Meeting Minute Ref	DRP Comment	Response
1.2	DRP commented upon the disconnect between the ground and the upper levels on the southern and eastern facades	The strength of the building form is two storey public treatment at base on all sides of the building. The upper floors have a different character based on room types behind and need for privacy. Eastern façade has more modulation and articulation due to main public face.

WEST & SOUTH ELEVATIONS

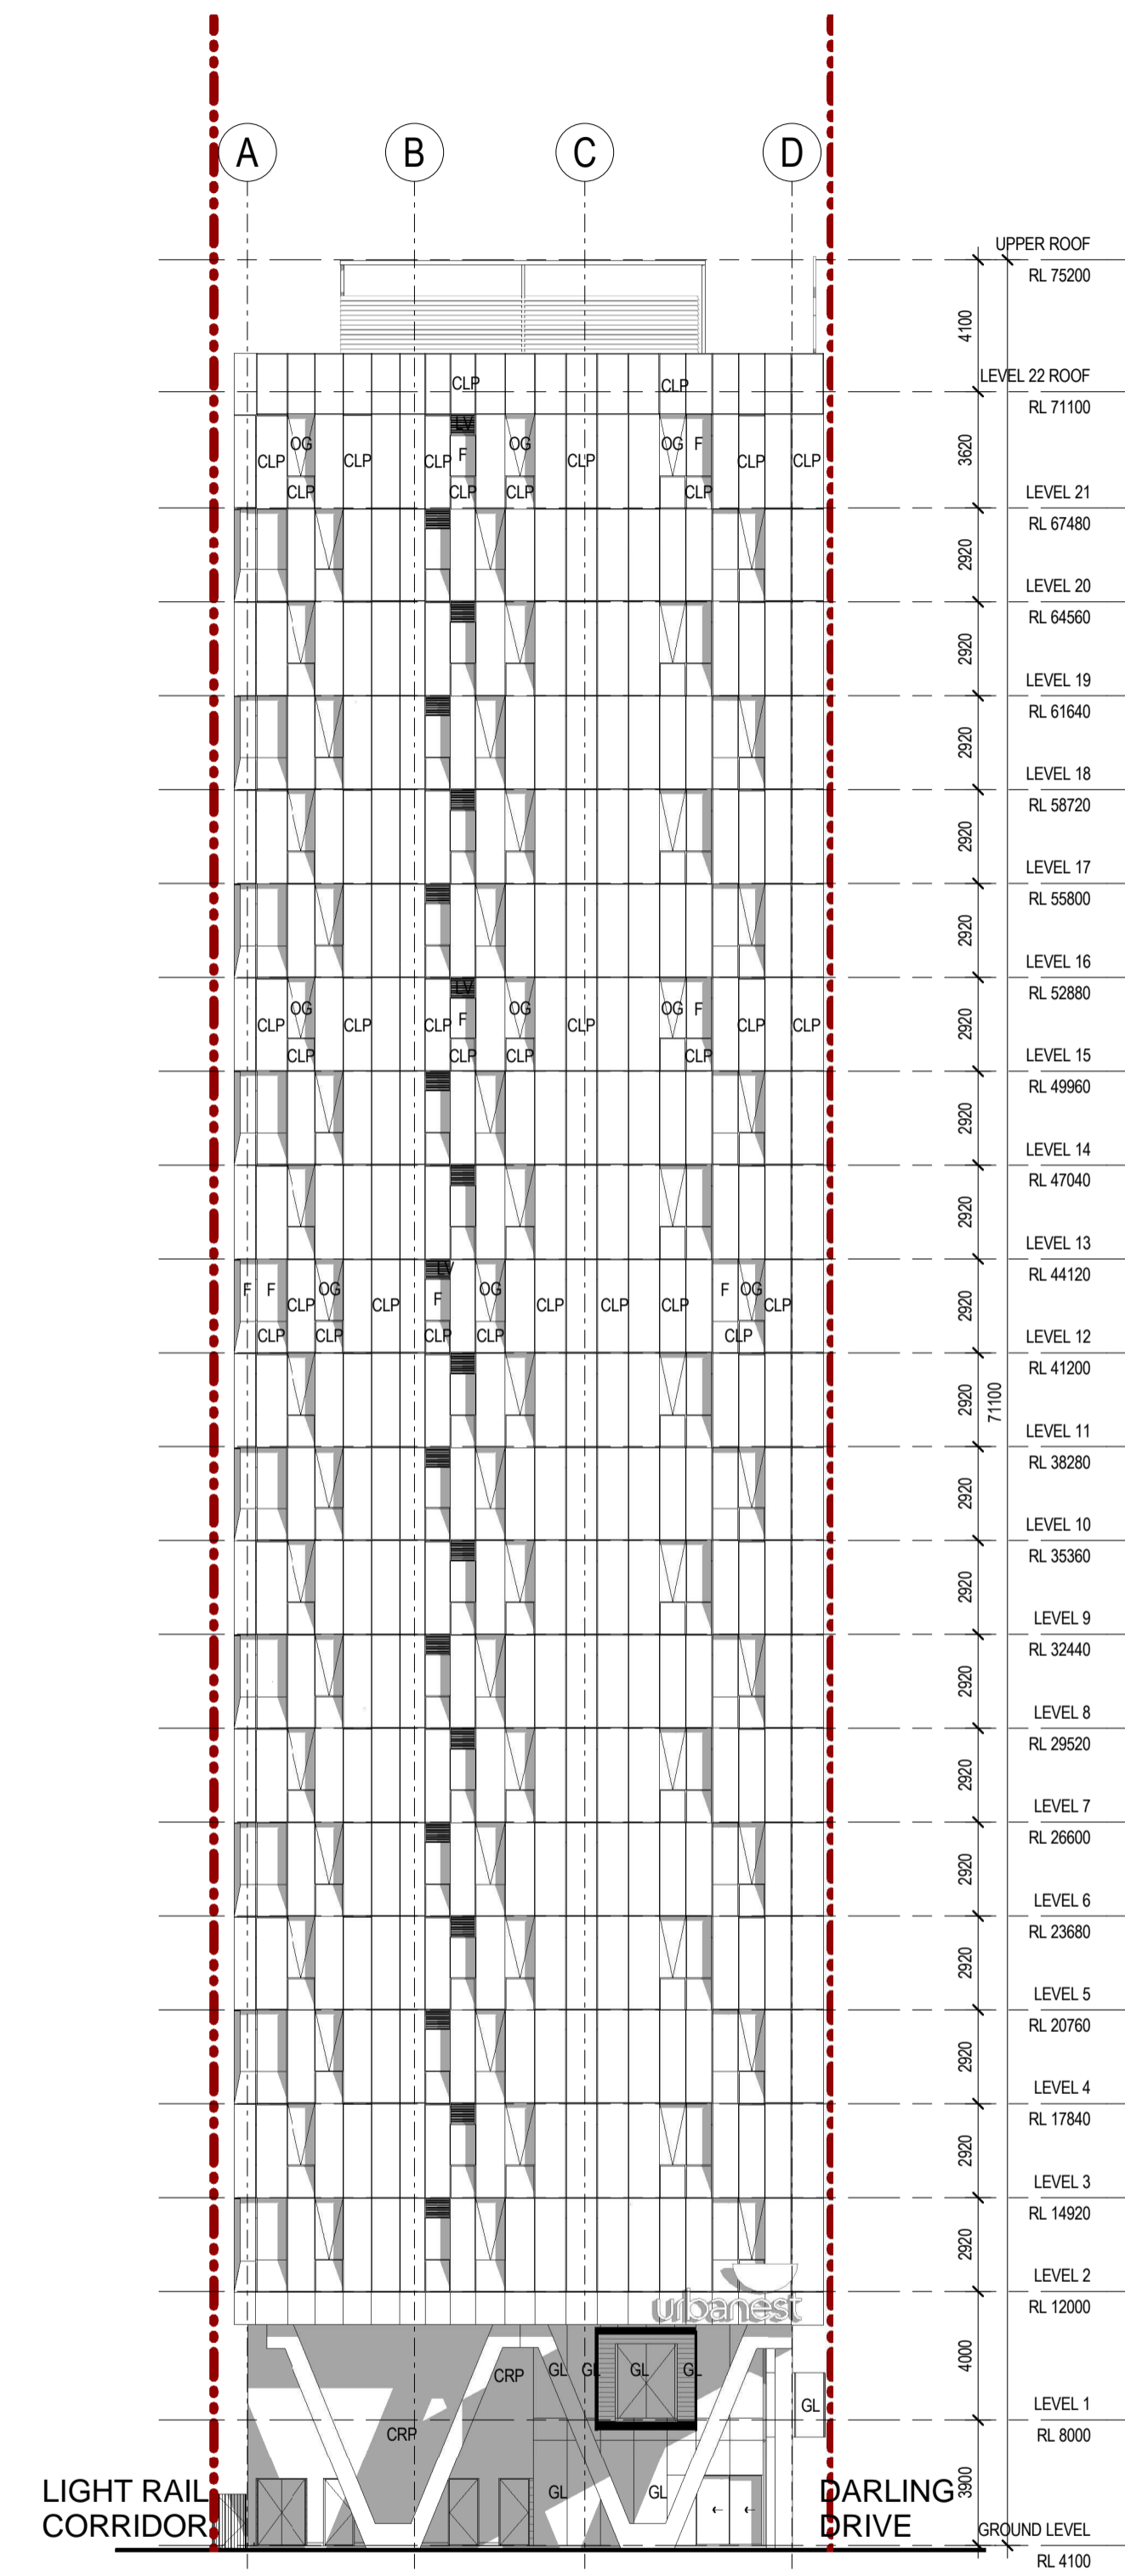
1.2	DRP recommended that a study be conducted of the Western walls of W1 and W2 together.	Elevations showing relationship of both the W1 and W2 buildings have been provided. This analysis illustrates the same design aesthetic with the W2 building with variations in window locations, module sizes based on room type and corridor locations.
2	DRP questioned the security of the courtyard area after hours.	<ul style="list-style-type: none"> <li>• The courtyard is afforded excellent surveillance through the location of the W1 reception immediately adjacent and the passing of students through the link bridge at all hours of day/night.</li> <li>• All pedestrian routes, entries and internal and external communal areas will be well lit along with lighting to the underside of the bridge link.</li> <li>• Entrapment opportunities have been mitigated through a revised amphitheatre design that reduces unused areas.</li> <li>• Suitable CCTV cameras will be installed within and around both the W1 and W2 building in appropriate locations with footage available in real time both site on site and remotely in Urbanest's Sydney head office.</li> </ul>
